9625 Otero Accessory Living Quarters, AL-21-1

Please accept the following comments from El Paso County Public Health (EPCPH) for the special use project referenced above:

0036528
EL PASO COUNTY HEALTH DEPARTMENT
COLORADO SPRINGS, COLORADO
DISPOSAL INSPECTION FORM

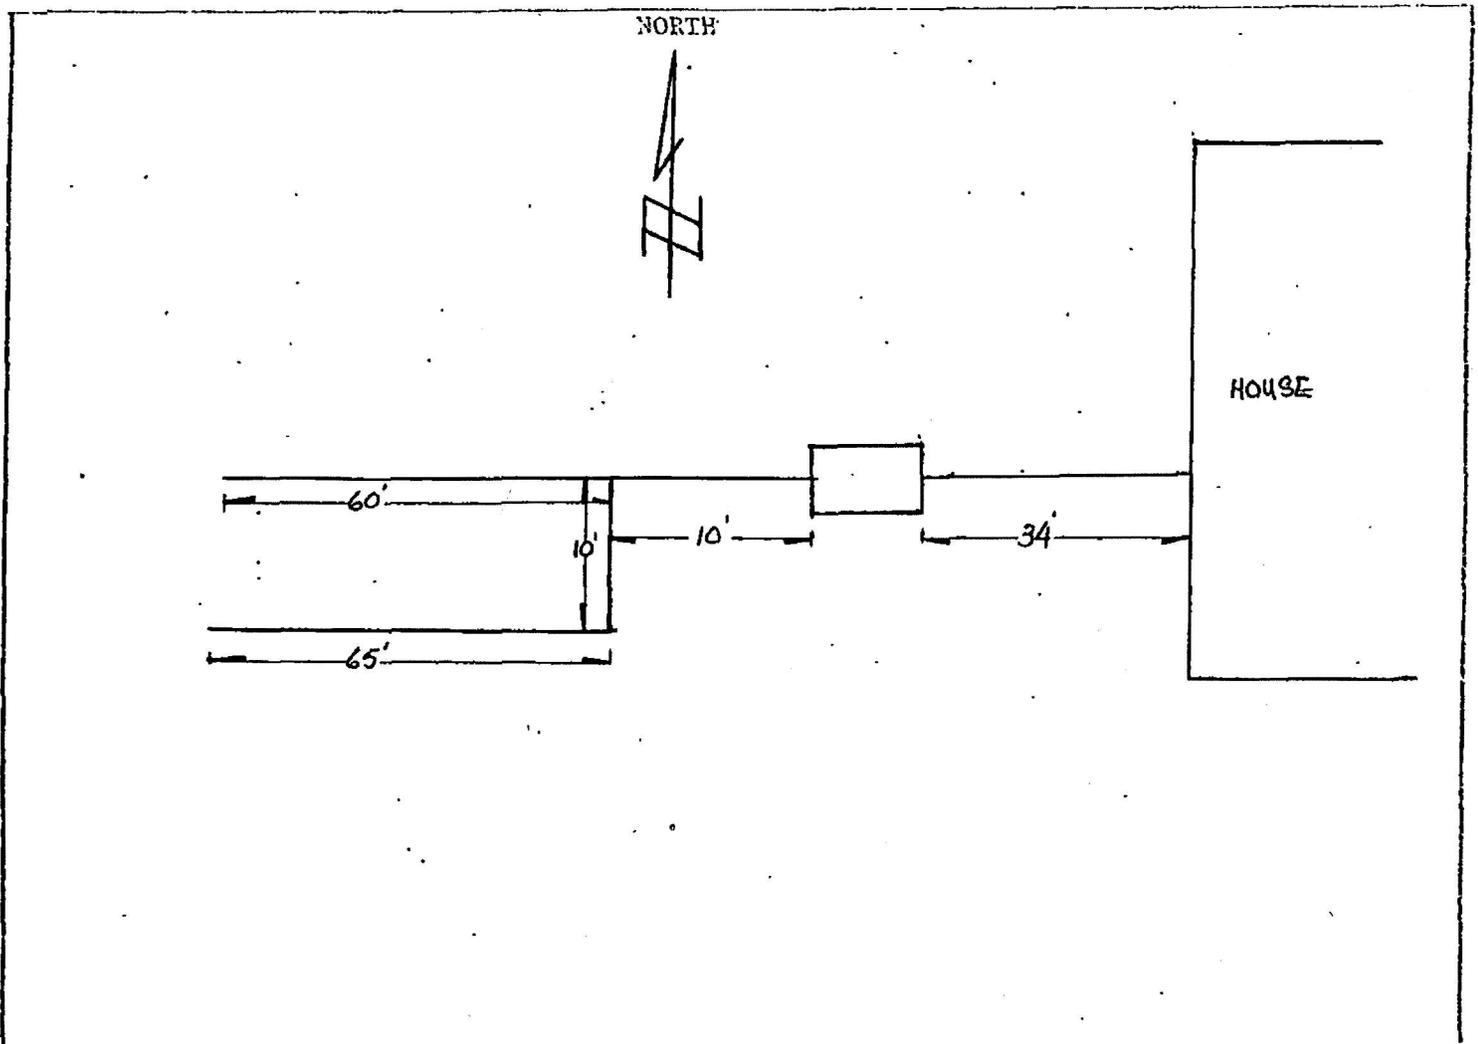
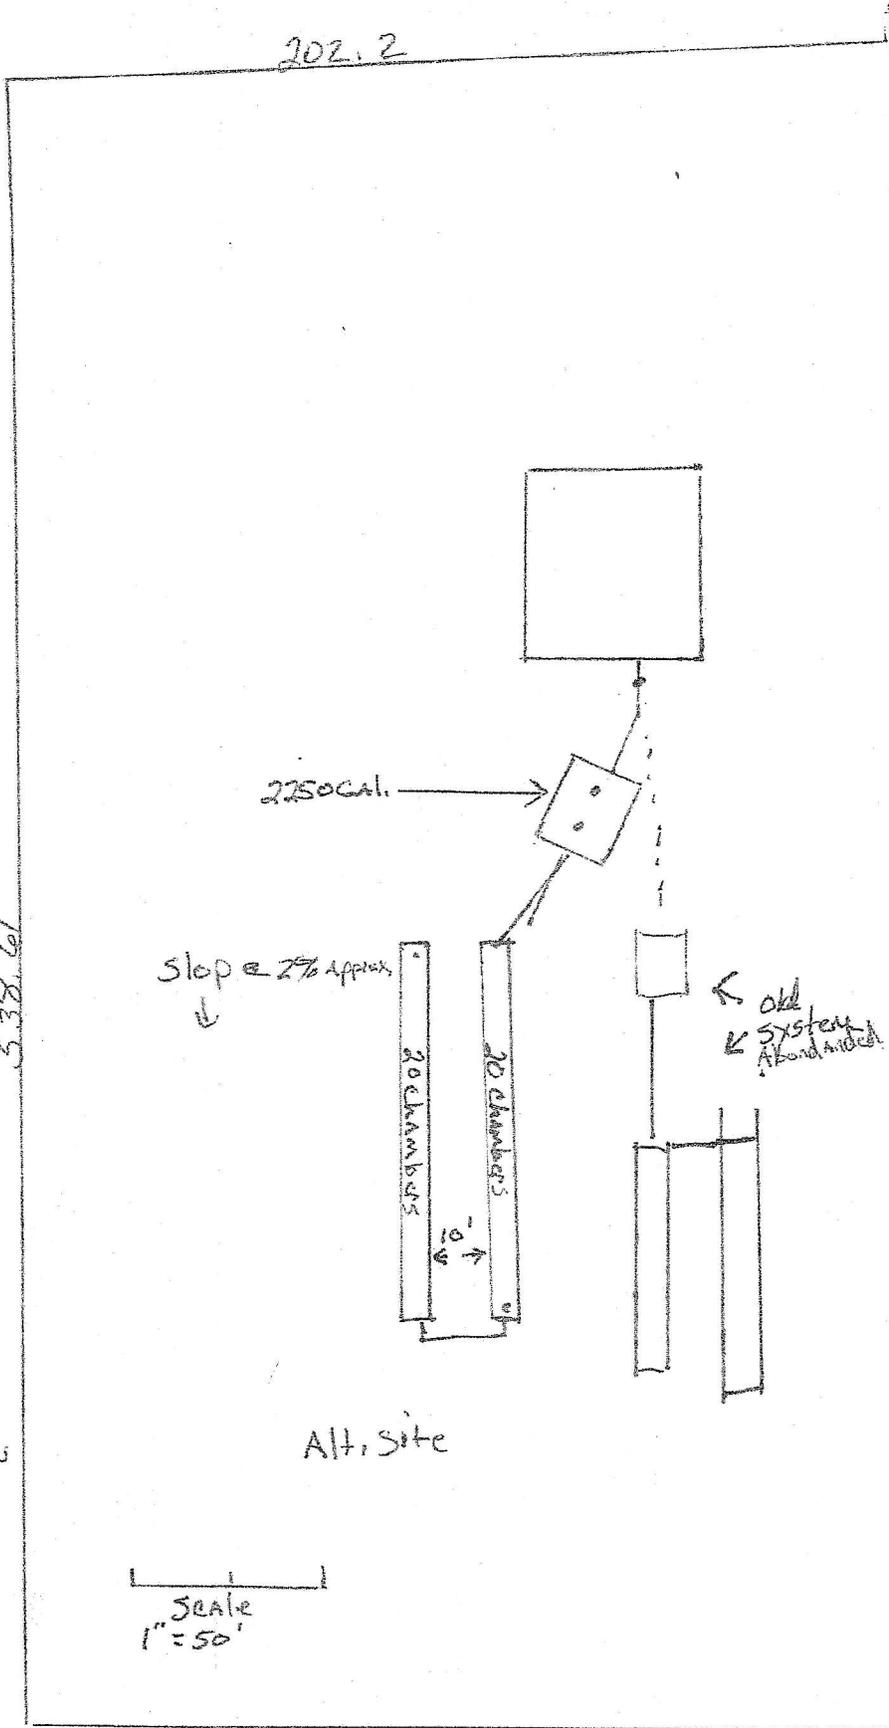
- Water service for the existing house is by an individual private well.
- Wastewater service for the existing house is an onsite wastewater treatment system (OWTS) permitted, installed and approved for a 6-bedroom house. The proposed new accessory living quarters will be connected to the existing 2,250-gallon septic tank and the existing 844 sq.ft. soil treatment area, both of which are adequate in size for the new living quarters.
 - An OWTS Minor Repair Permit is required for the connection of the new living quarters to the existing septic tank.
- The existing water line must meet the setback to the new wastewater line or the wastewater line must be properly encased as specified in the OWTS Regulations.
